**158 Fore St**

**M E M O**

RE: 158 Fore Street (Hotel) (Eplan # 2015-169)

Final Review Comment from the Department of Public Works:

Design by:	MPM	Checked by:	SJB
Drawn by:	JAR	Approved by:	SJB
Project:	150.06094	Date:	AUGUST 2015
Sheet No:	C1.0		
	Sheet 4 of 17

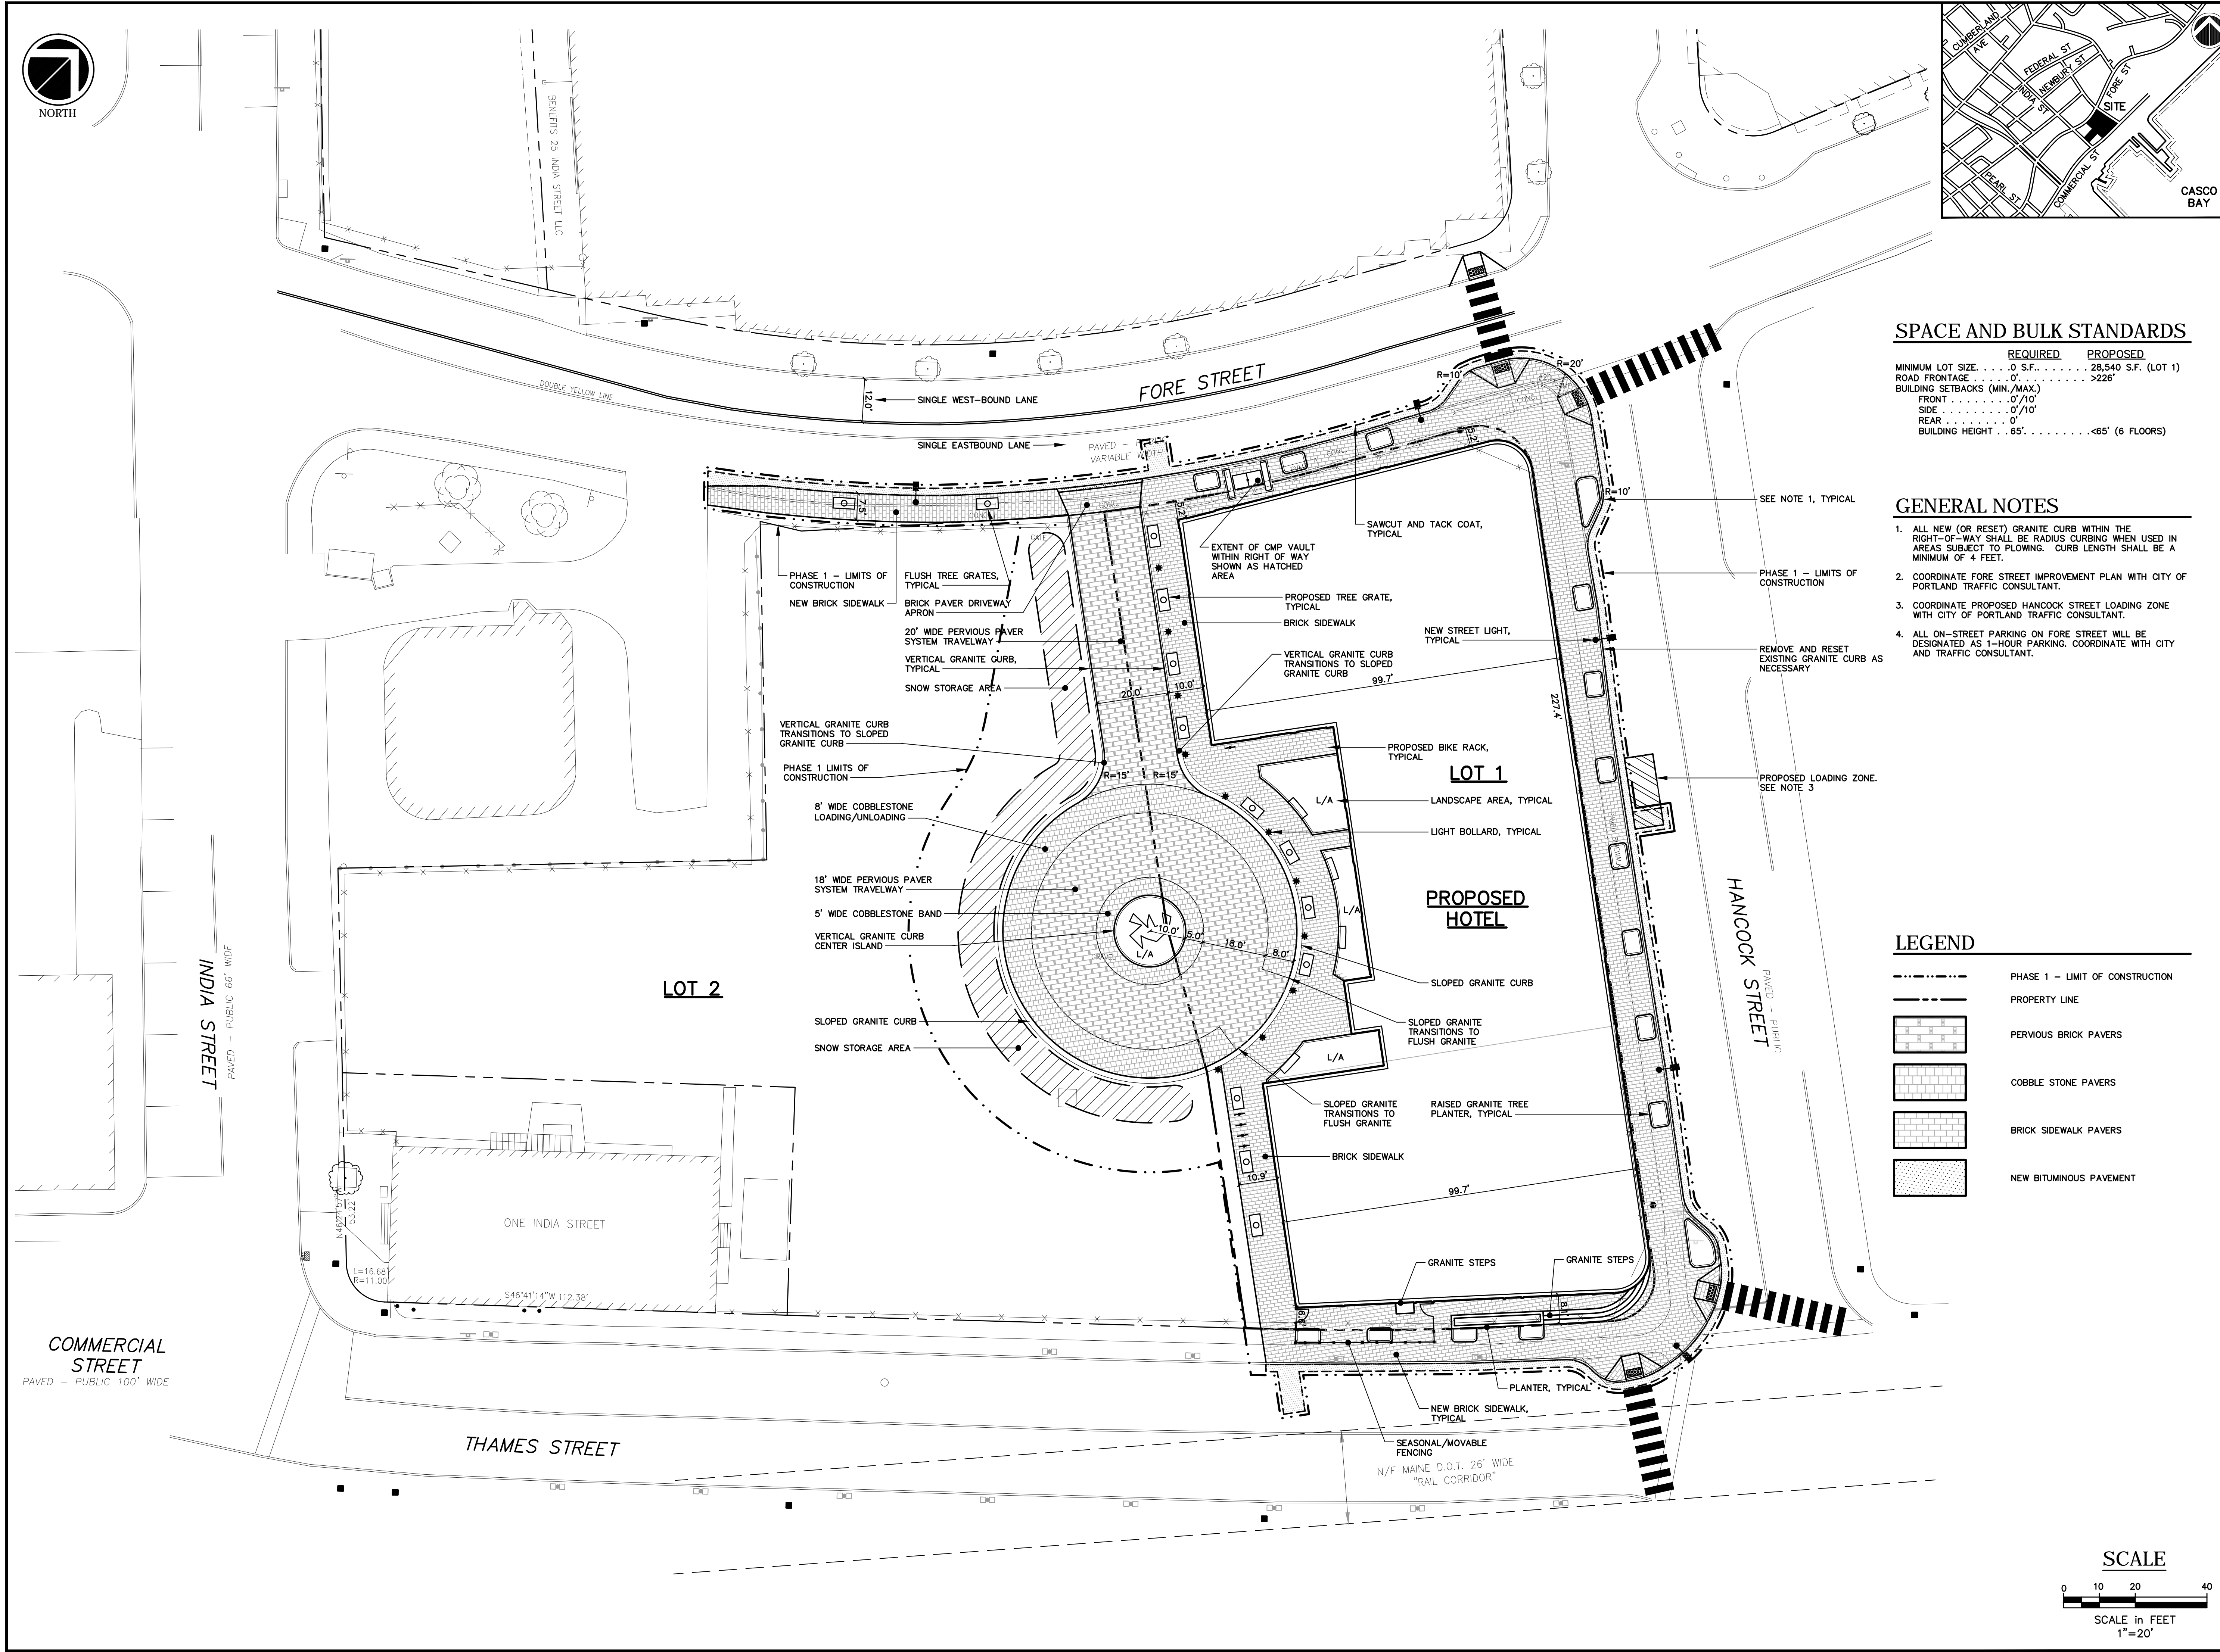
1. Sheet C1.0 – Site Plan, the applicant is showing a brick driveway apron and has asked where the code states an asphalt drive is required. It is my understanding that the City Council in 2000 passed such a material policy and that any change from this policy requires Council authorization.
2. Sheet C1.2, Grading, it is desirable to have the pedestrian crossings of Fore St and Hancock St Extension be perpendicular. This issue will need more discussion.
